CITY OF ALBUQUERQUE

August 8, 2022

Re: **IMPERIAL INN**
701 Central Ave NE
Traffic Circulation Layout
Architect's Stamp **NONE** (K14-D226)

AS-103-2

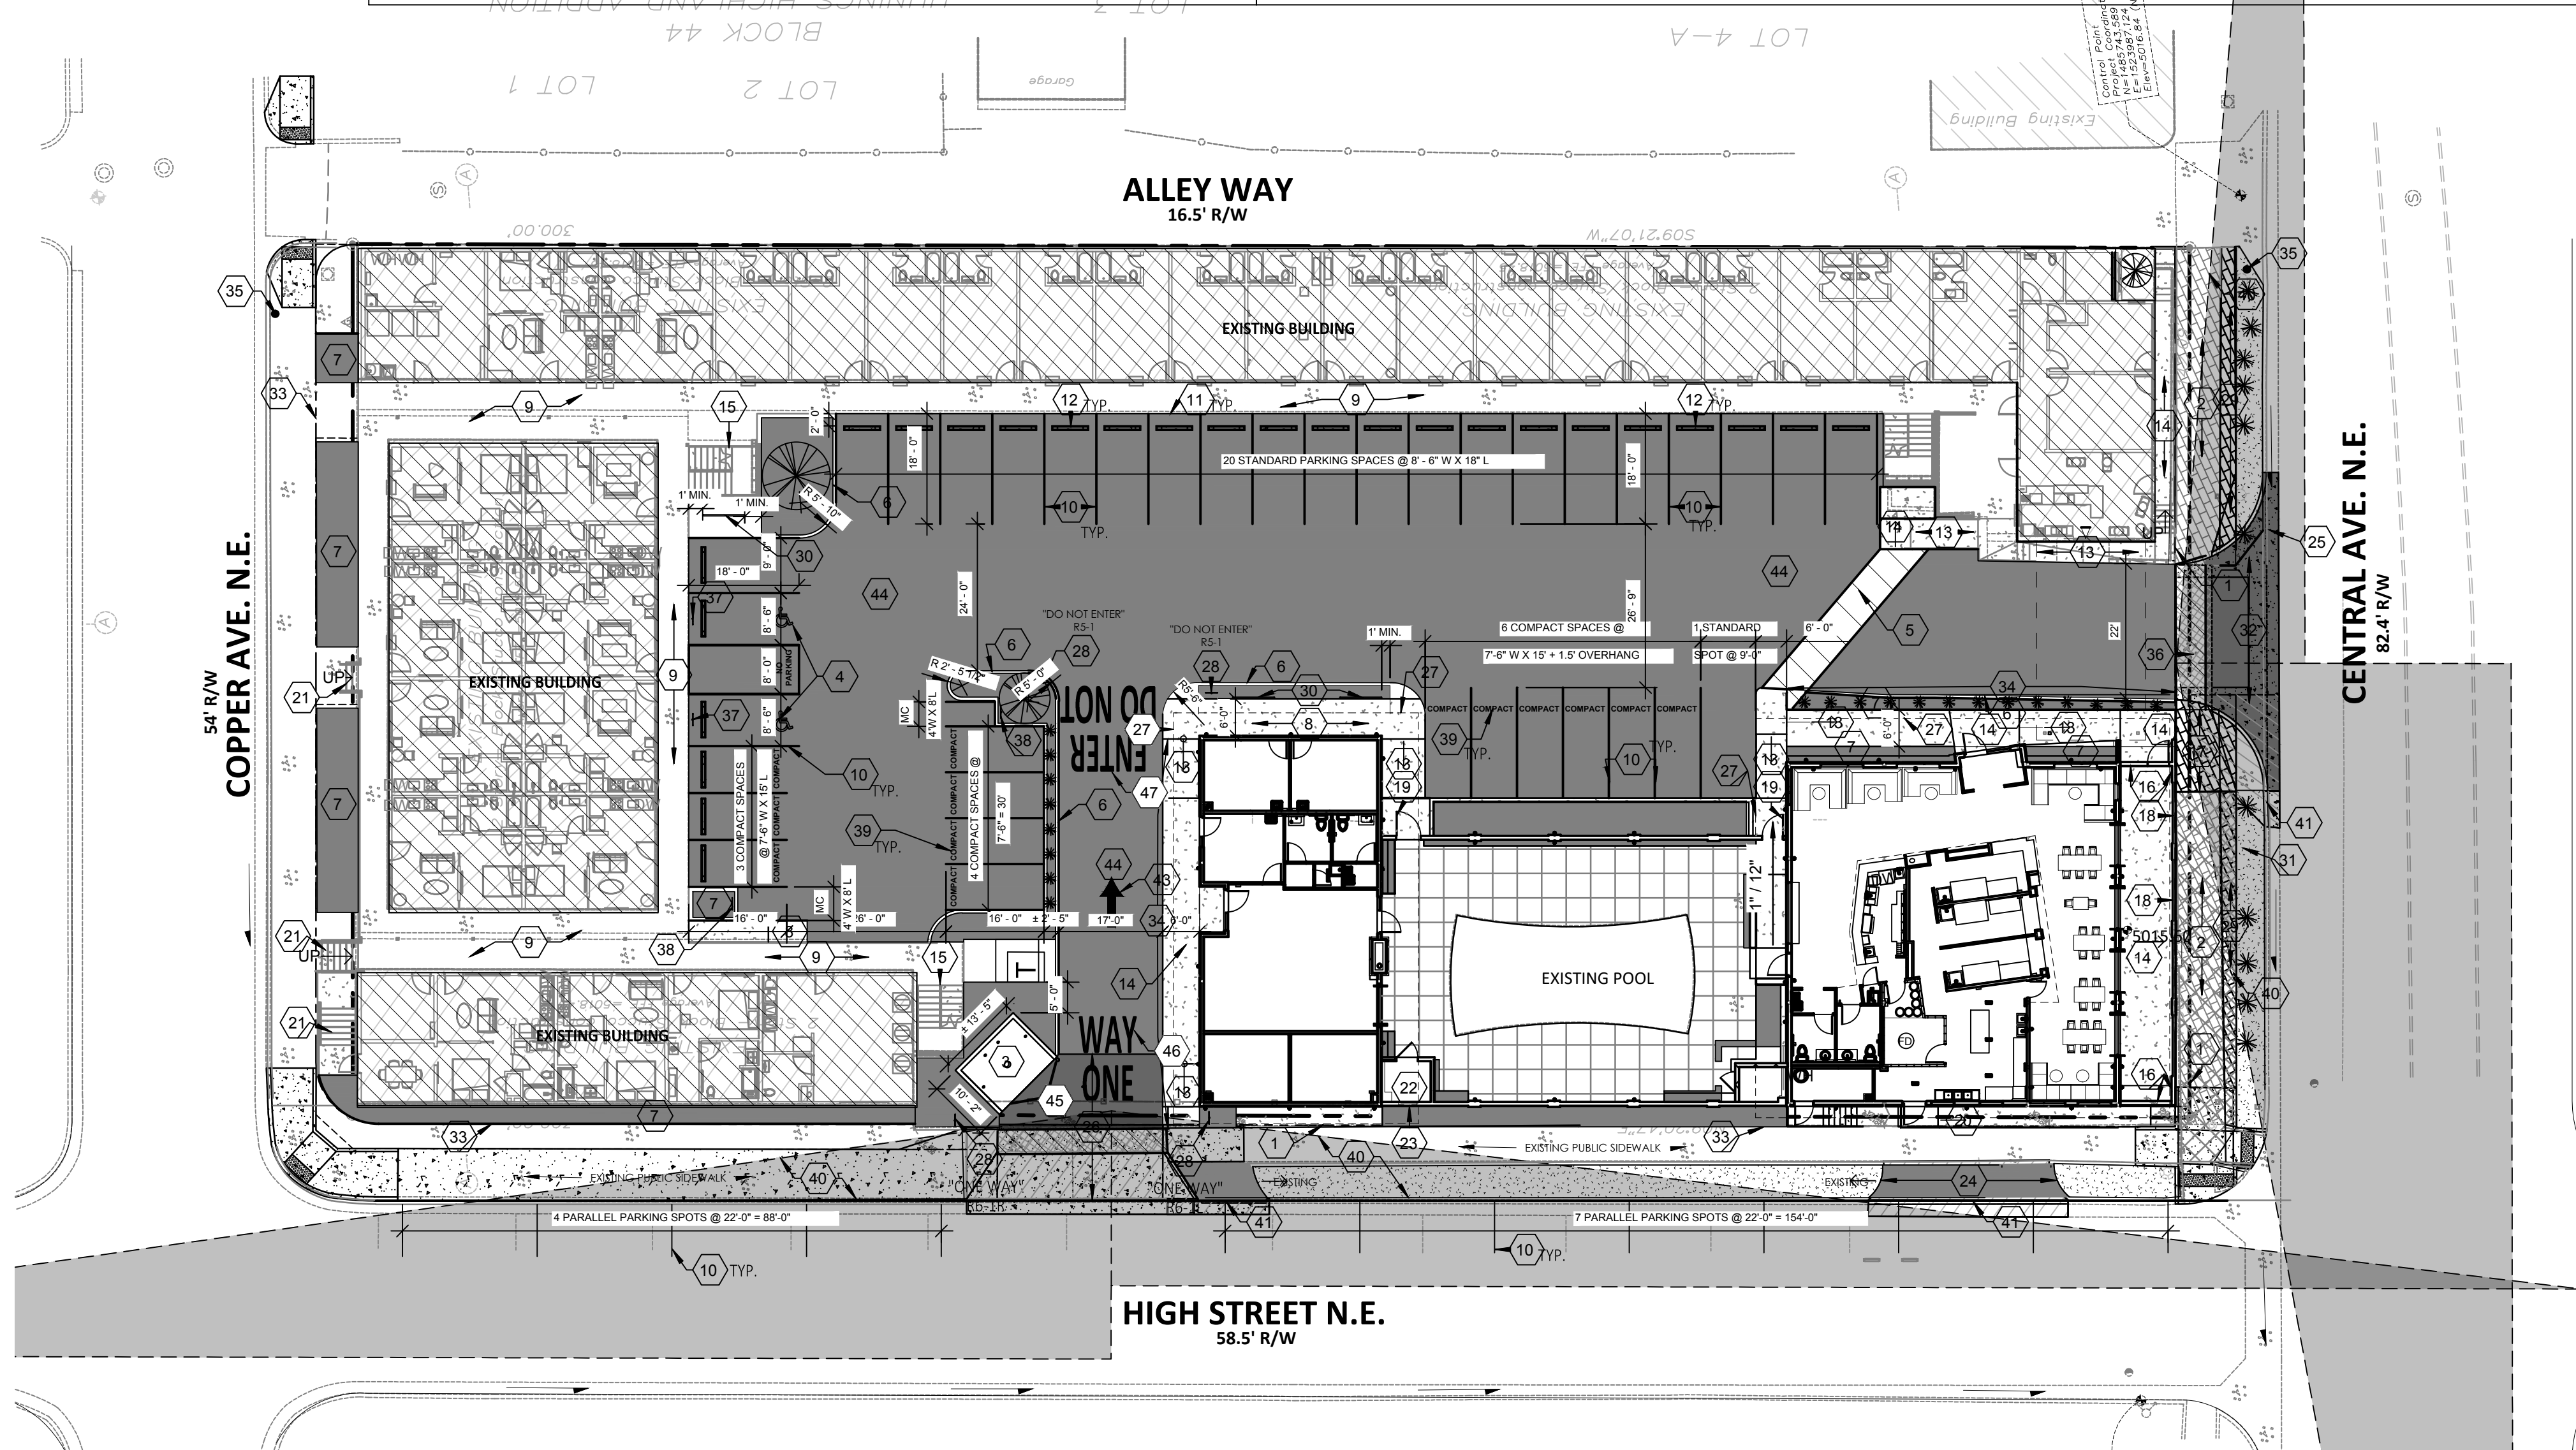
- You will need to provide an ADA ramp across the alley. Please provide details.
13. All Keyed Note sheets that reference will need to be provided as well as any proposed infrastructure (details needed).

14. **Keyed Note 20:**
- Please verify that the private ramps and door openings do not encroach into COA ROW.
 - The proposed ramp do not create a safety issue adjacent to public sidewalk.

15. **Keyed Note 25:** The 8 ft wide delivery ramp will note allowable within the COA ROW and existing driveway/pad will need to be closed accordingly.

16. **Keyed Note 26:**
- Provide detail for proposed driveway design and/or reference COA std dwg's.
 - The proposed drivepad design is in conflict with sidewalk connection from private property to public sidewalk. Please address this safety concern.

17. **Keyed Note 28:**
- Proposed signage and pavement markings will need to be located on private property.
 - And details will need to be provided for sign face, pathway striping and pavement markings.

18. **Keyed Note 29:**
- Please provide proposed public sidewalk design since it is a patterned type of design.
 - All widening of public sidewalk will not be tagged into existing sidewalk widths. Please address this concern.

- The end of proposed public sidewalk widen has create a safety concern at corner ramp (ramp taper/wing) connection of the intersection of Central/High Street. Please address this situation.

19. **Keyed Note 32:**
- The existing entrance driveway will need to be replace with a curb return type of driveway design since it is off Central Ave (Principal Arterial). Please see COA std dwg 2426 for reference.

21. Please list the width and **length** for proposed parking spaces. Some dimensions are not shown.

32. Show all drive aisle widths and **radii**. Some dimensions are not shown.

35. Per the DPM, a 6 ft. wide ADA accessible pedestrian pathway is required from the public sidewalk to the building entrances. Please clearly show this pathway and provide details.

36. Per DPM, a 6 ft. wide ADA accessible pedestrian pathway is required from the ADA parking stall access aisles to the building entrances. Please clearly show this pathway and provide details.

41. All one-way drives shall have "One Way" and "Do Not Enter" signage and pavement markings. **Please provide detail and location of posted signs and striping.**
